Application Ref:	3/2025/0539				Ribble Valley Borough Council www.ribblevalley.gov.uk
Date Inspected:	N/A	Site Notice:	N/A		
Officer:	AR/LW				
DELEGATED ITEM FILE REPORT:					APPROVAL

Development Description:	Certificate of Lawfulness for a proposed single storey side extension.
Site Address/Location:	7 Aspen Crescent Barrow BB7 9ZL.

Proposed Plan & Elevations

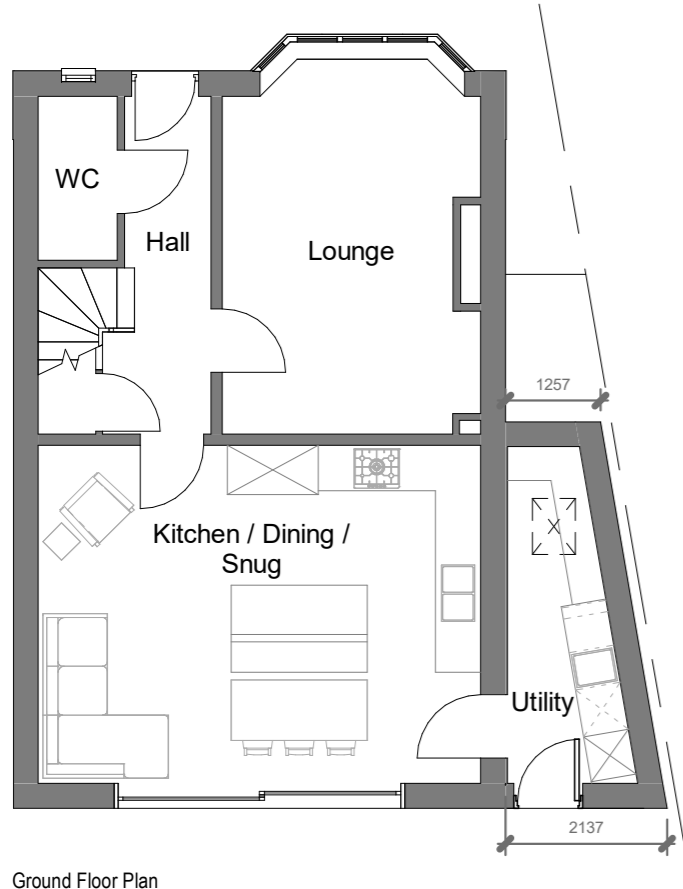
Consent is sought for the erection of a single storey extension to the side of the property. It is proposed that the extension will project up to 2137mm sideways.

The extension will benefit from an eave's height of 2527mm and a maximum ridge height of 3620mm.

The proposed ridge height of the single-story extension (3620mm) does not exceed the height of the highest part of the roof of the existing dwelling.

The proposed eaves height of 2527mm would not exceed the height of the eaves of the existing dwellinghouse.

The proposed extension is within two metres of the boundary of the curtilage. However, the maximum height of the eaves is 2527mm and therefore the proposal complies with the above.

The proposed extension would extend beyond the side elevation of the dwellinghouse. However, the proposal is single storey, less than 4m in height and does not have a width greater than half the width of the original dwelling.
